ITEM 1.8 (a)

**85 Harrington Street
The Rocks
GOLDEN AGE & HANNAS THE ROCKS**

**RESPONSE TO DoPE
ITEM 1.8 (a)**

TITLE
**Plans
Adaptable and Livable Housing Guide**

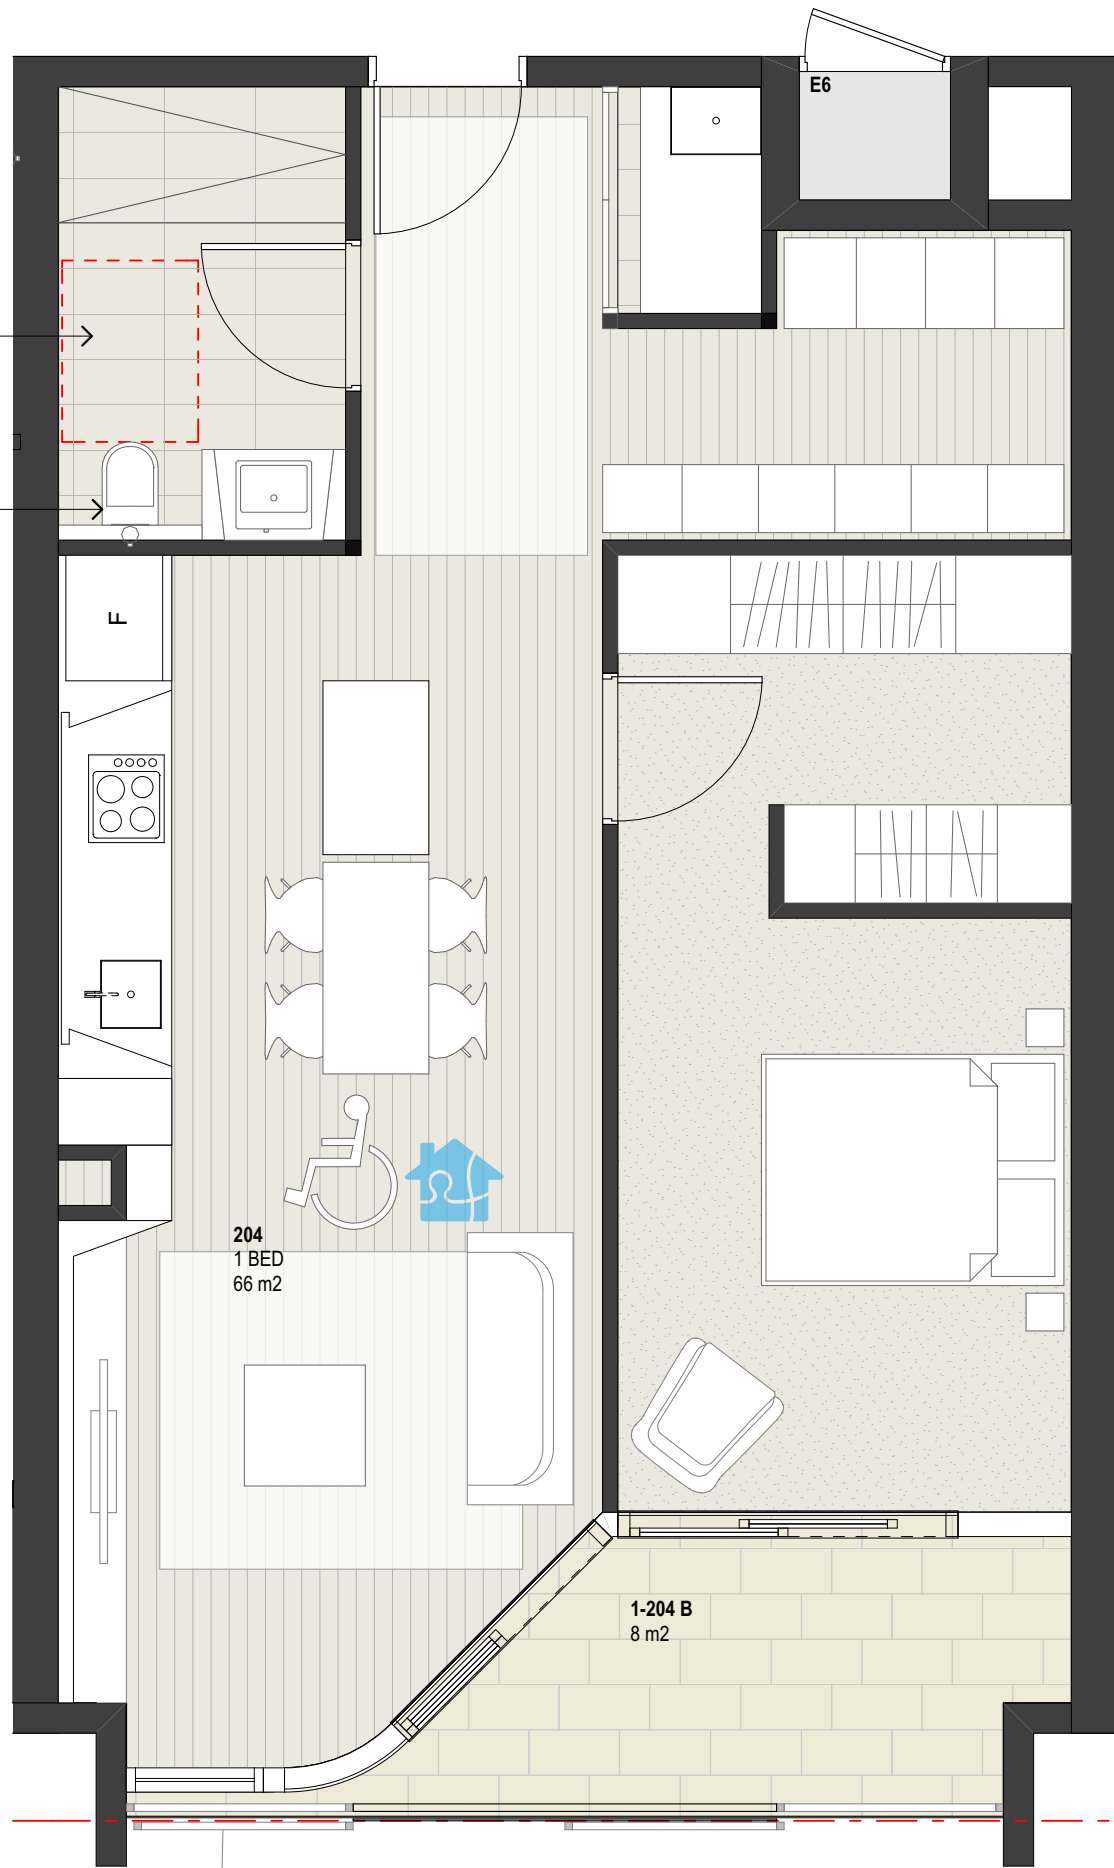
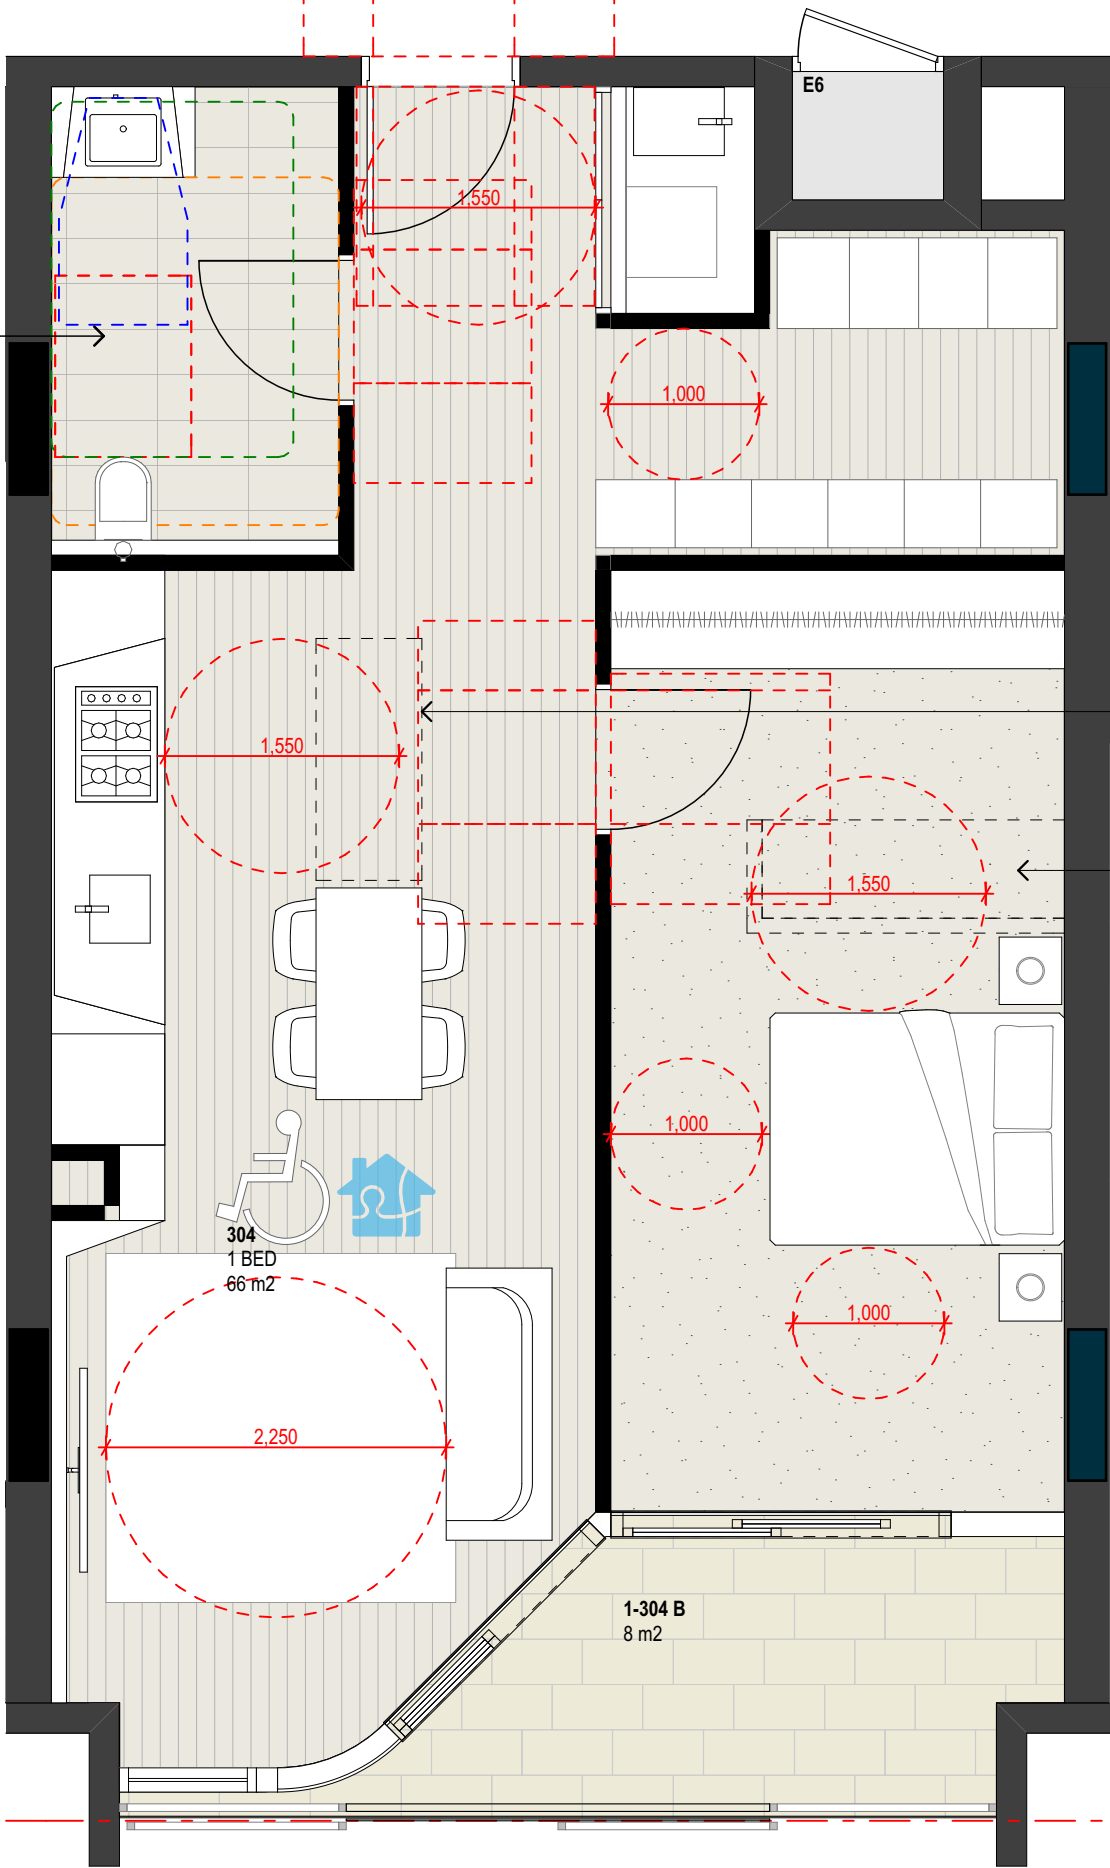
Description:
The Department's overall analysis indicates units 202, 203 and 204 (and identical units on the levels above) may not benefit from a satisfactory level of amenity due to a combination of variations to the Apartment Design Guide design criteria including solar access, cross ventilation, unit depth and/or lack of an external bedroom window.
The Department particularly notes the units which exceed 8 min depth are also not cross ventilated, further reducing effective air flow.
Please undertake further consideration of the design of these units to ensure a suitable level of amenity for future residents is achieved.

- Furthermore, apartment 204 (and identical units above) take into consideration the needs for adaptability for accessible future residents.

- The apartment has been amended to ensure that the bedroom receives natural daylight and air from a window in an external wall.
